WEST SUSSEX COUNTY COUNCIL CONSULTATION

TO:	Arun District Council FAO: Simon Davis
FROM:	WSCC - Highways Authority: Tim Townsend
DATE:	26th February 2021
LOCATION:	Land At Wings Nursery Lidsey Road Woodgate PO20 3SU
SUBJECT:	AL/20/21/PL Demolition of Wings House & erection of 71 No. replacement dwellings (70 net new dwellings), access arrangements, sustainable drainage measures, public open space, landscaping & all other associated works (resubmission following AL/46/20/PL). This application is a Departure from the Development Plan.
DATE OF SITE VISIT:	n/a (visited as part of the assessment undertaken for previous proposals AL/117/17/OUT, AL/32/19/OUT and AL/46/20/PL).
RECOMMENDATION:	More Information Required
S106 CONTRIBUTION TOTAL:	TBA

This is the WSCC Highways (CHA) response to the above planning application for demolition of Wings House & erection of 71 No. replacement dwellings (70 net new dwellings), access arrangements, sustainable drainage measures, public open space, landscaping & all other associated works (resubmission following AL/46/20/PL).

Drawing No.
2019-6115-002

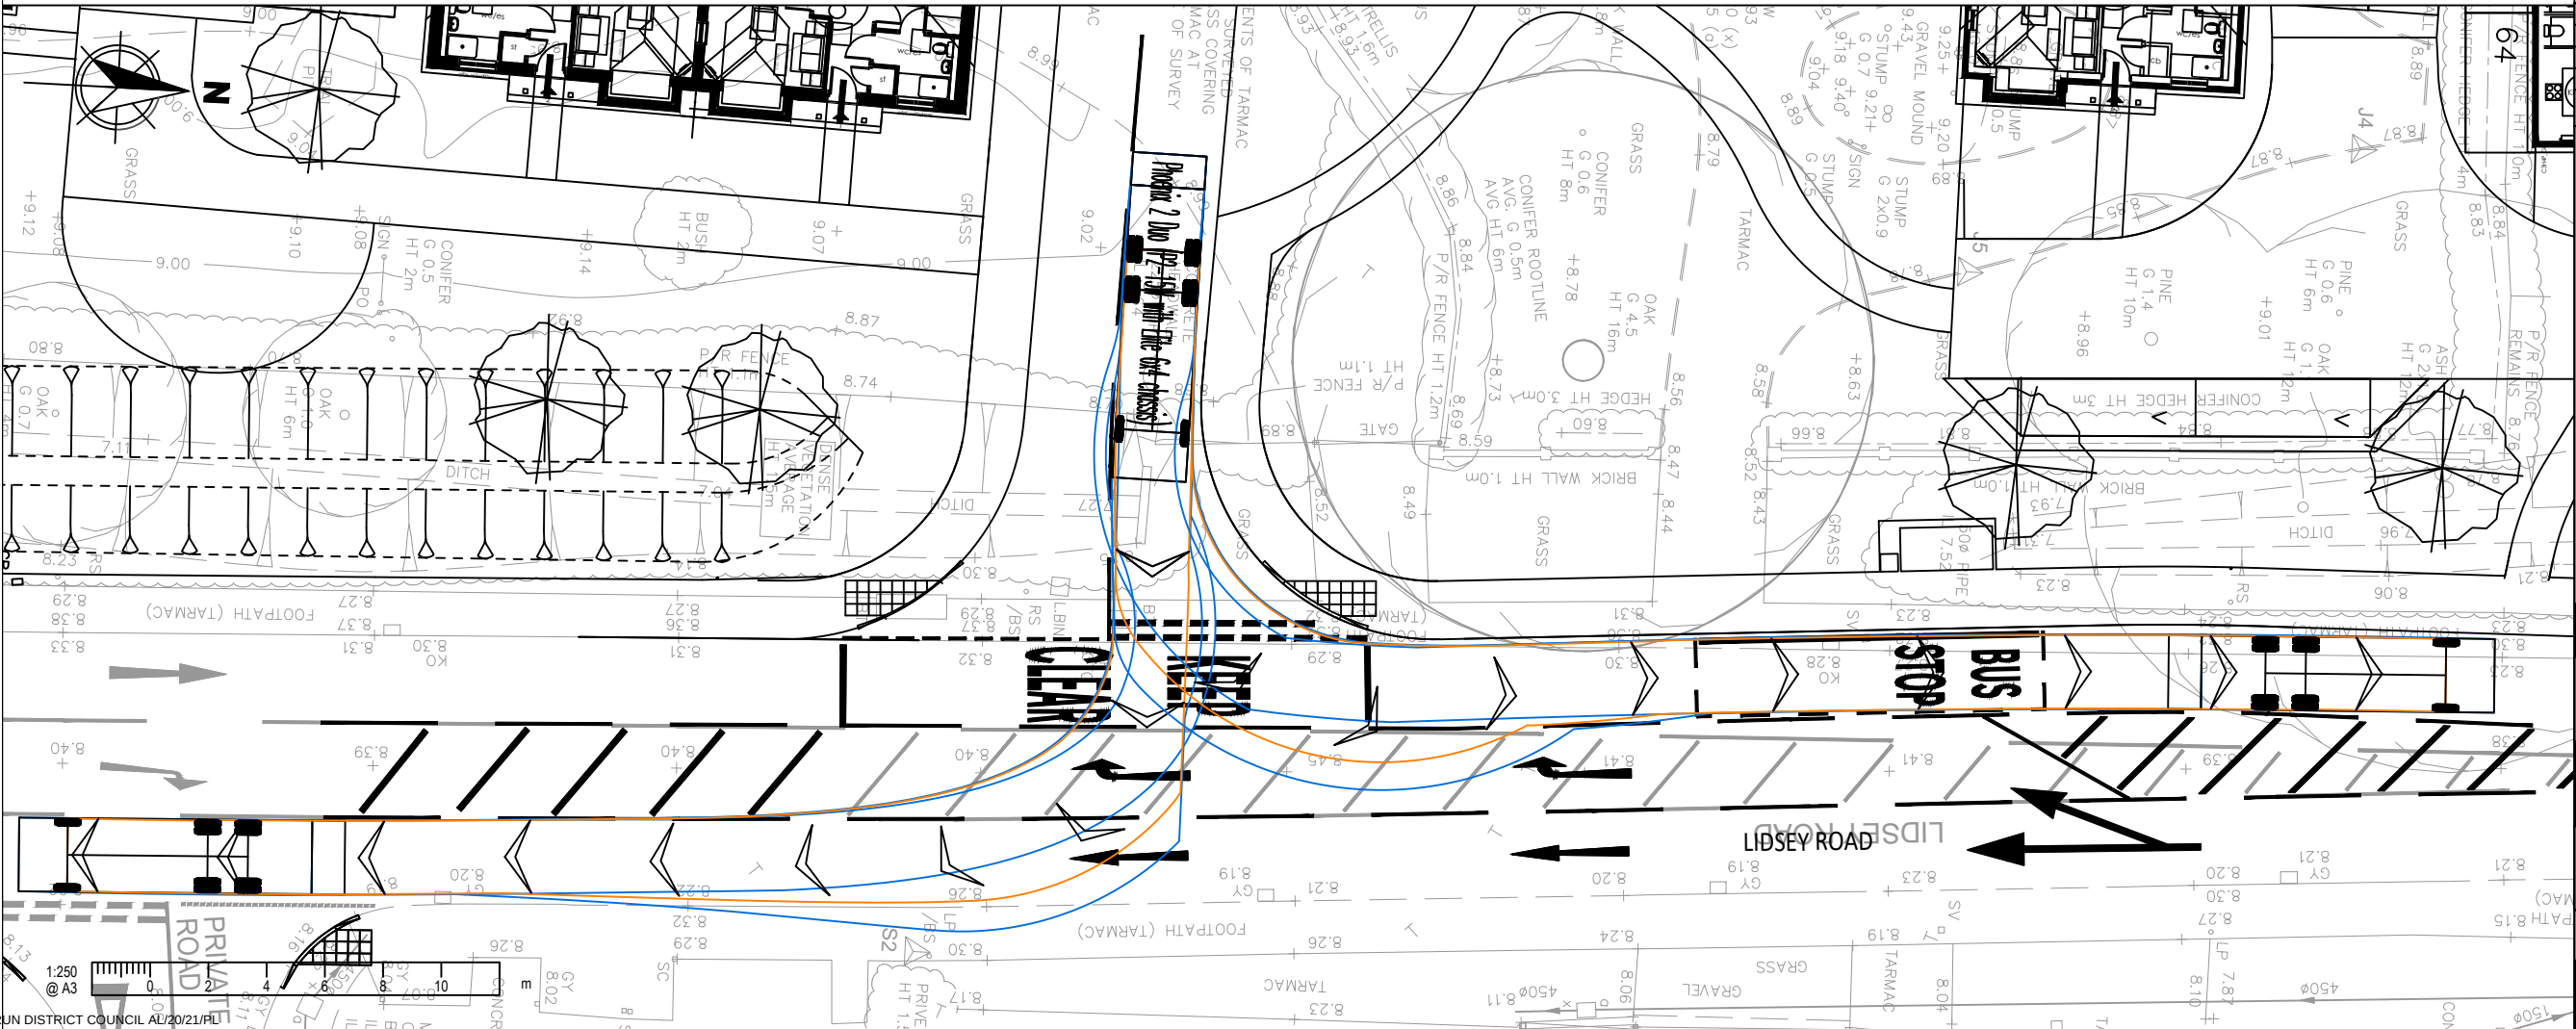
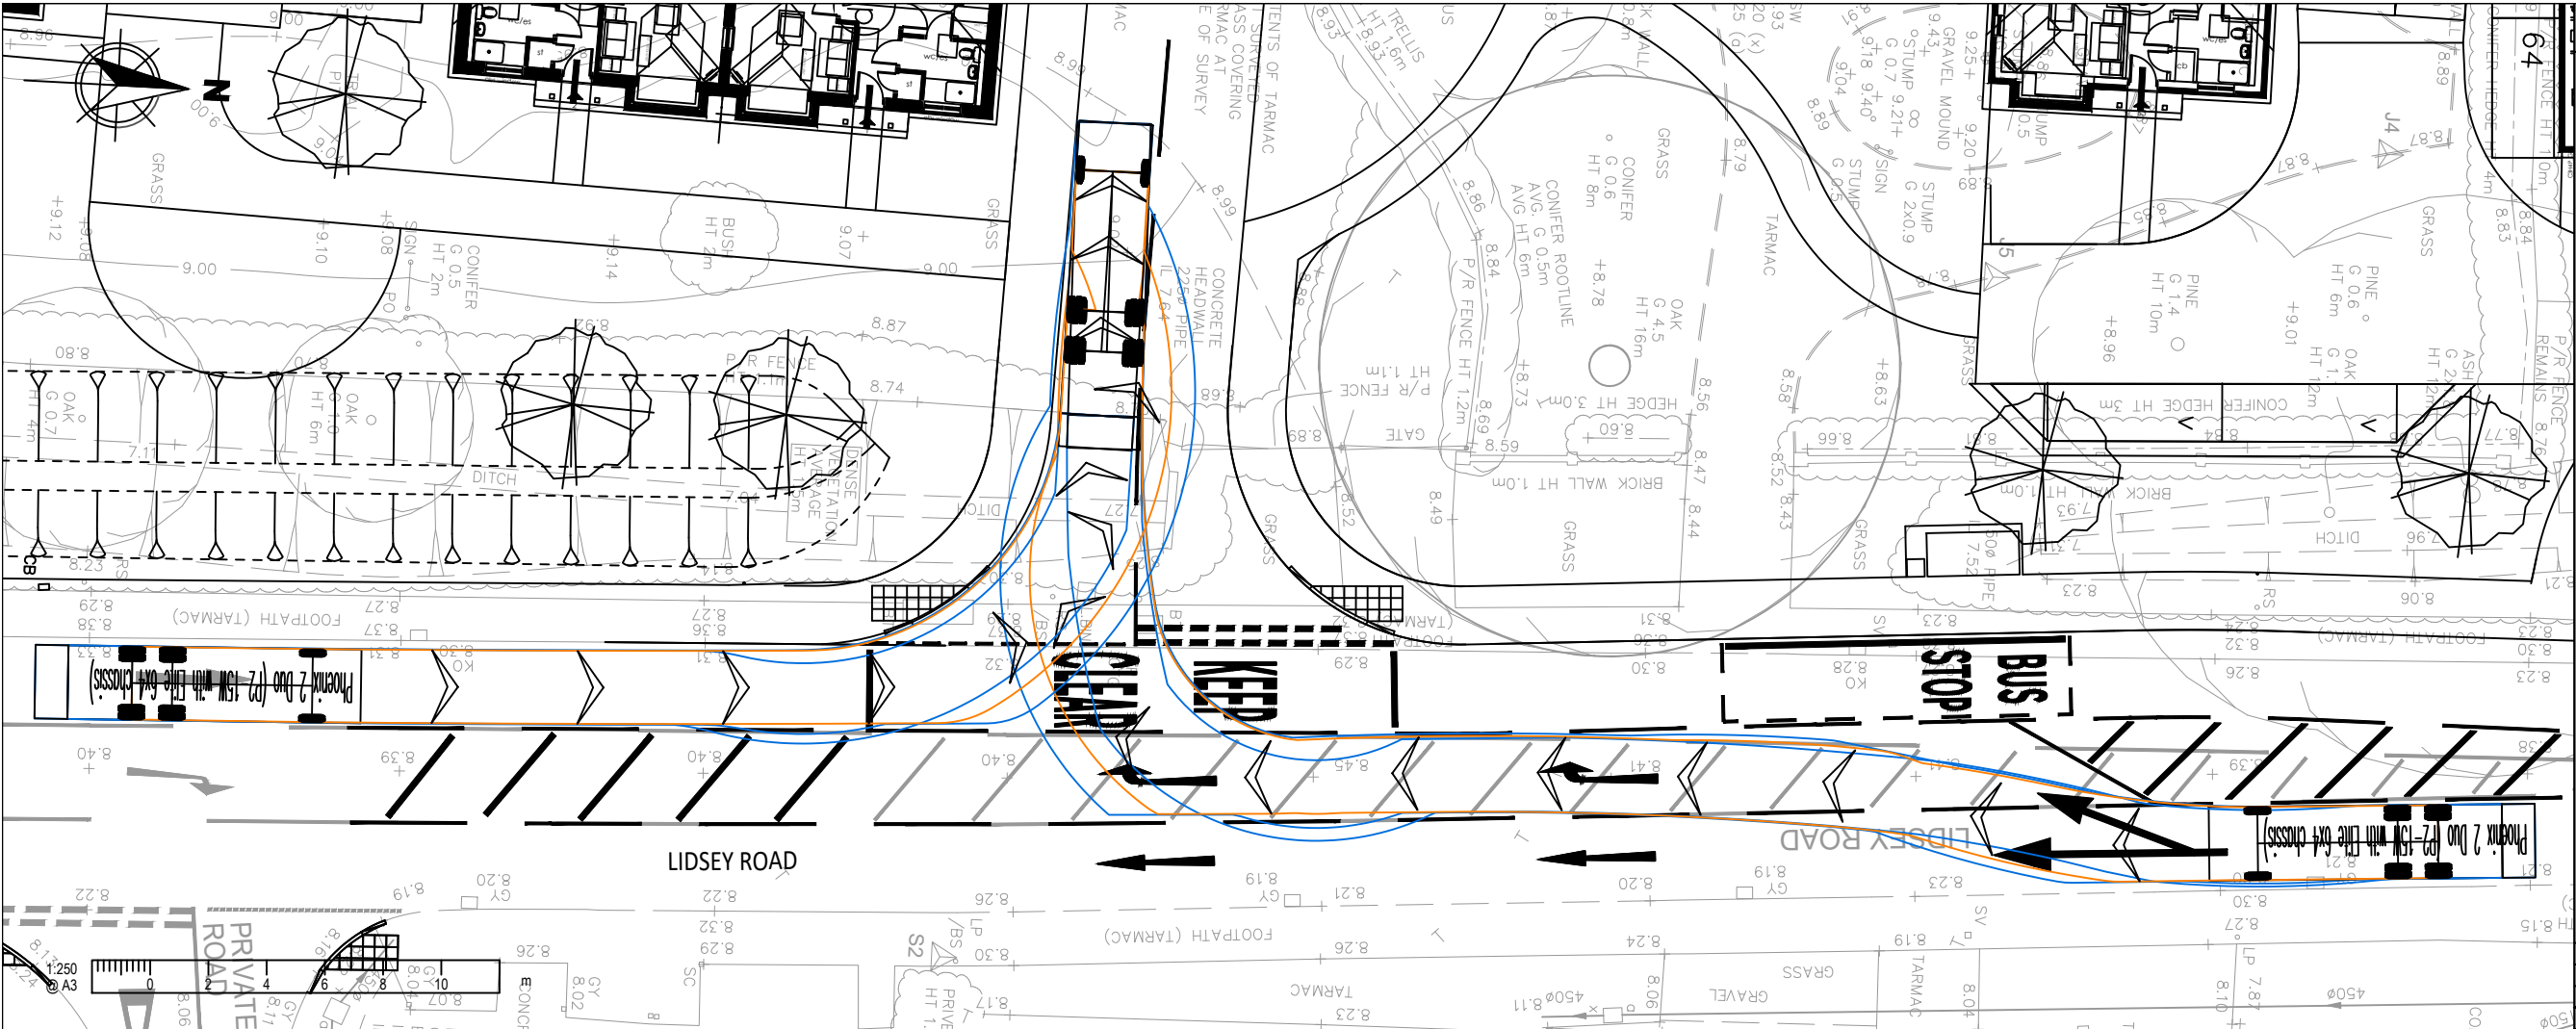
final design to the Highway Authority's satisfaction (covers both access points and associated works to the public highway). However and specifically with regard to the secondary access, the applicant does need to demonstrate that the turning area for a refuse vehicle is large enough (a tracking diagram for a fire appliance has already been provided). A plan and tracking information to demonstrate the latter is required.

- A tracking diagram should be provided showing a refuse vehicle turning in the turning area in the private 'secondary driveway' adjacent to plots 63 and 64.
- A tracking diagram for a selection of vehicles should be provided showing their path around the proposed relocated north-bound bus stop marking on the A29. As shown, there appears to be a potential conflict point where vehicles attempting to overtake a stationary bus would enter part of the right hand turning lane which could result in collisions. As a result, the bus cage and bus stop might need moving. This element of the re-design should also be passed to the Road Safety Audit Team to review and comment on.

- Turning for a refuse vehicle is not demonstrated adjacent to plots 63 and 64. Furthermore, another area of concern is the width of the access road serving plots 5-10. This appears to be 4.1m wide which is easily blocked if a vehicle were to park on it. This should be widened to a minimum of 4.8m wide.
- Given the lack of service margins and location of some of the parking immediately adjacent to parts of the internal roadways, the layout would not be suitable for adoption under S38 in its current guise.

1. Tracking diagram for a refuse vehicle adjacent to plots 63 and 64.
2. Tracking for a selection of vehicles travelling north-bounds negotiating a stationary bus in the re-located bus stop north of the primary access.
